From: Joan Baxter [REDACTED]
Sent: 07 April 2021 15:17
To: Planning <Planning@arun.gov.uk>
Subject: Planning ref. R/45/21/HH

We are next door neighbours to no. 33 Bushby Avenue.

Proposed Ground Floor Plan

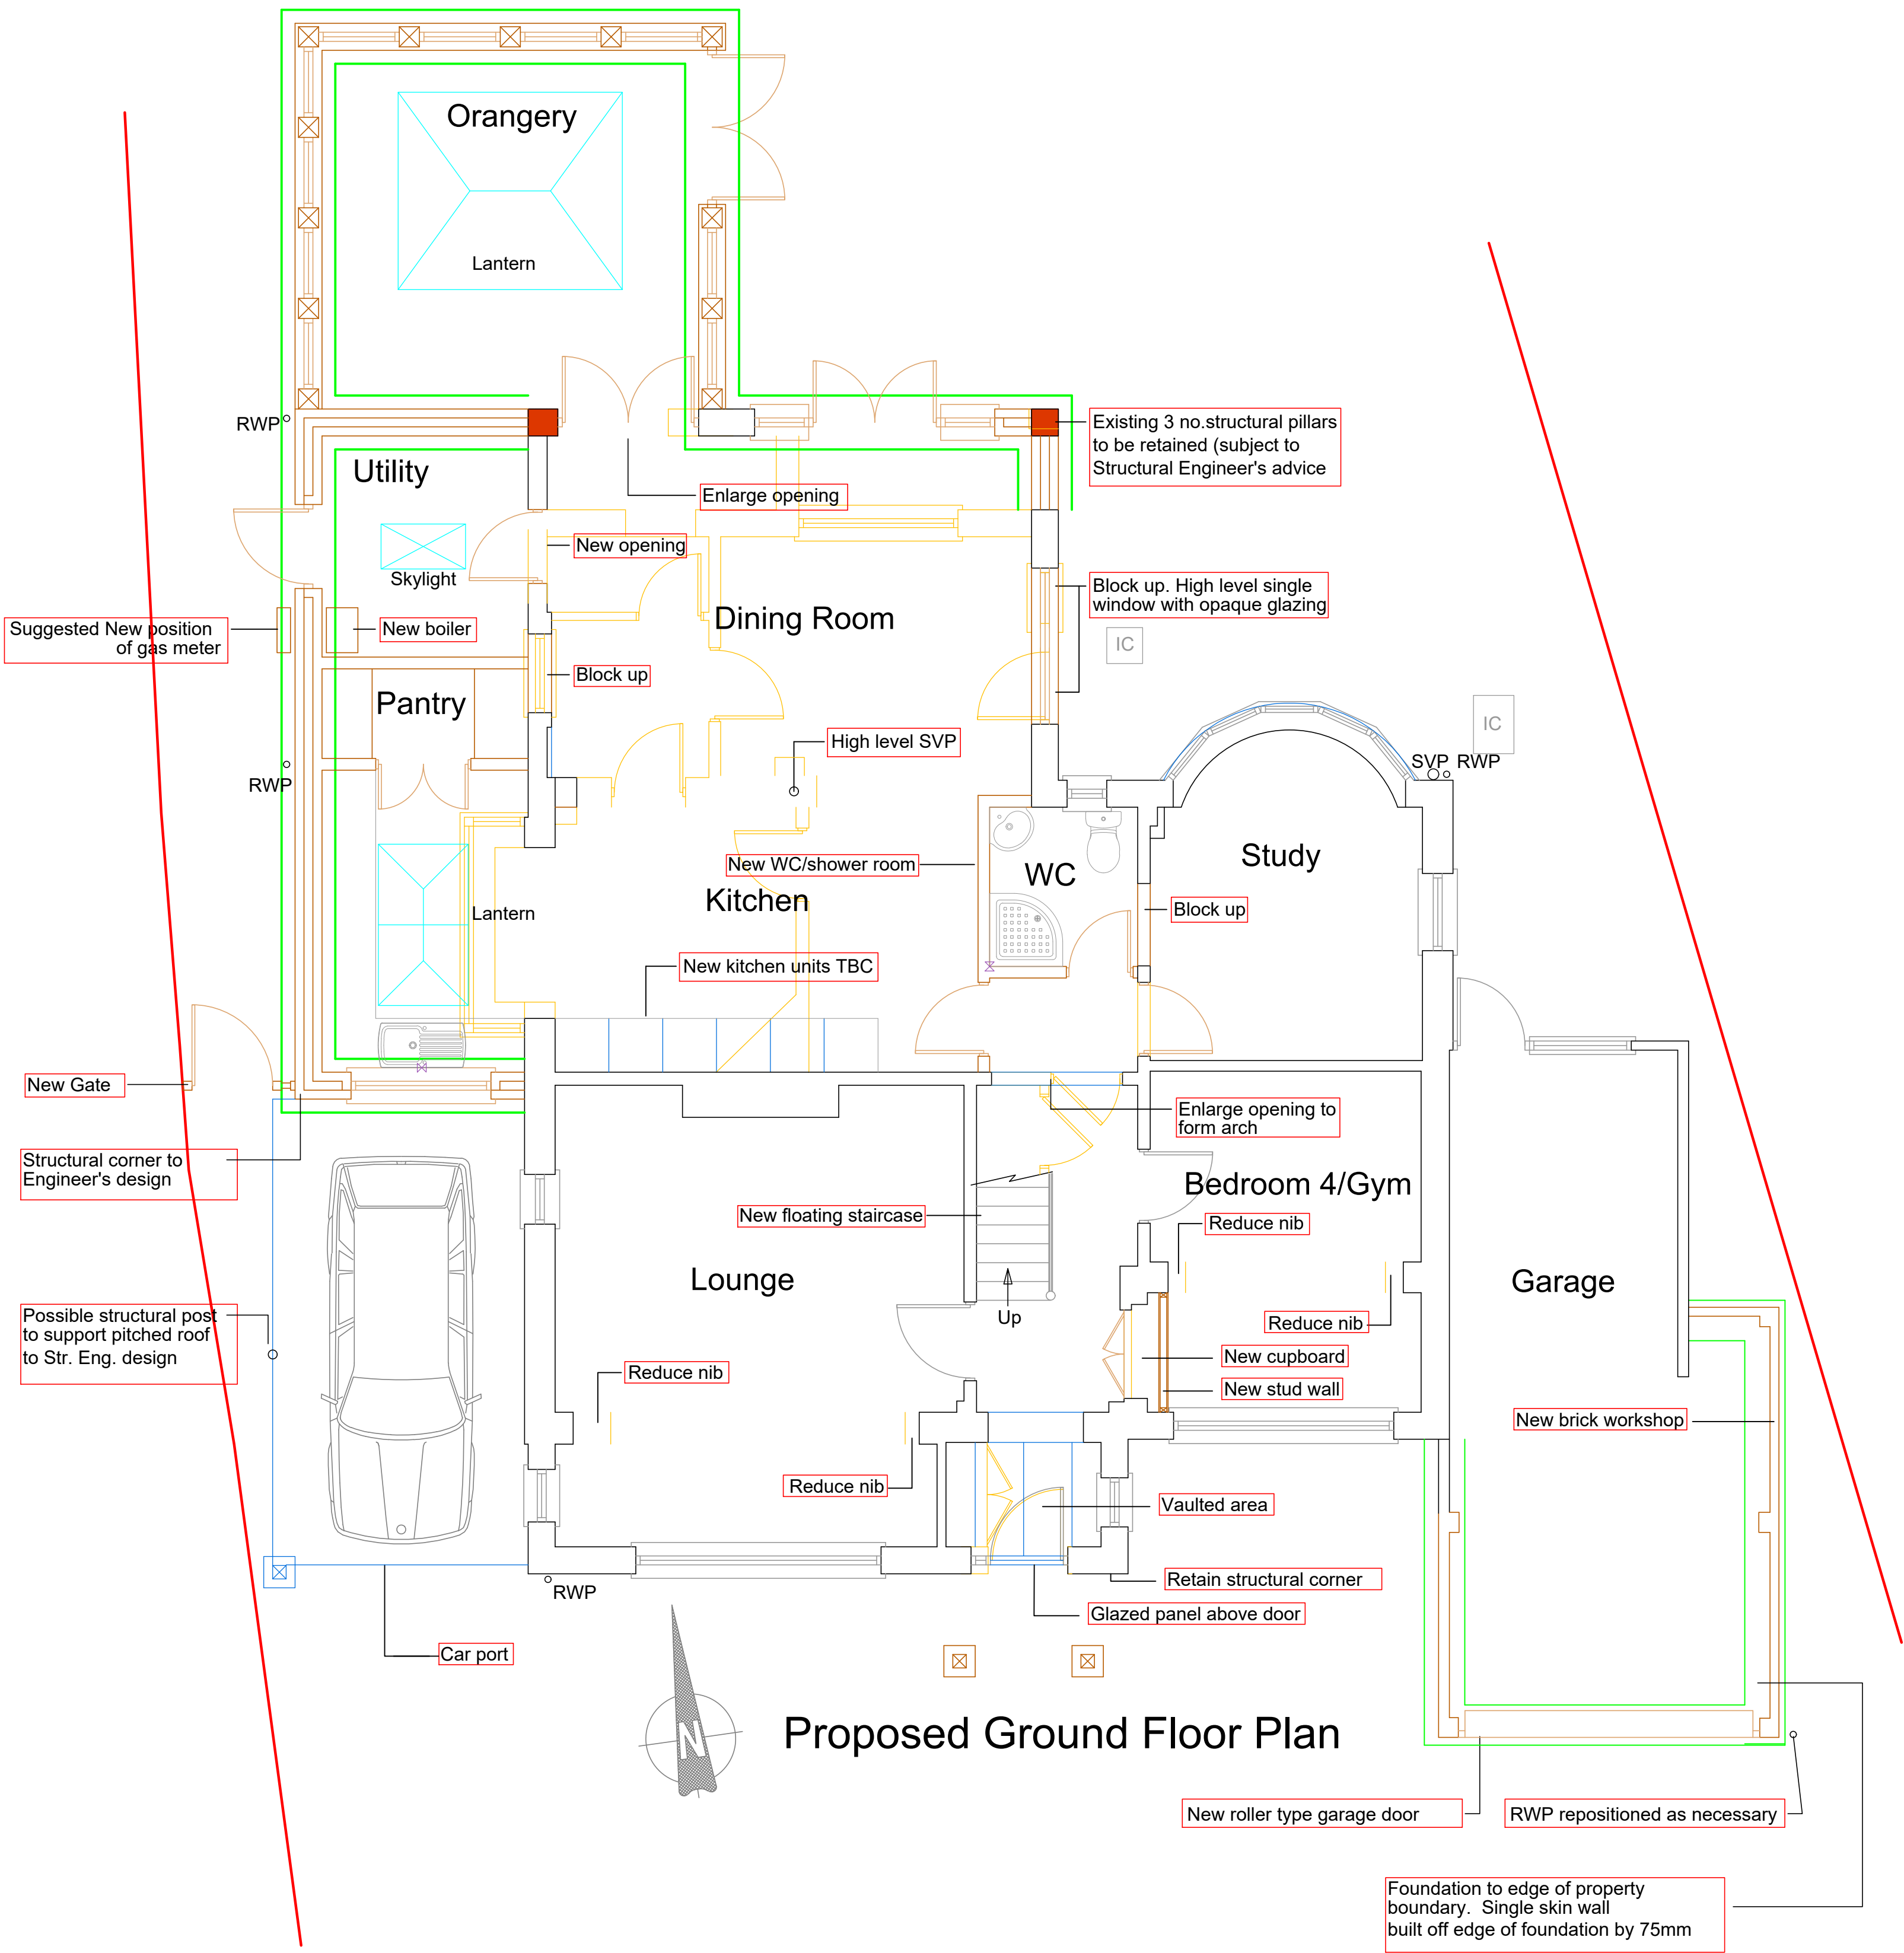
1. that the proposed car port roof, which extends to our boundary, will not drain rain water across the boundary;
- and 2. that any kitchen extractor fans do not vent directly across our boundary.

With regard to point 2, we have previous experience of this in our former home. It was a significant nuisance with regard to strong cooking odours, noise from the fan and concern about any potential health impact.
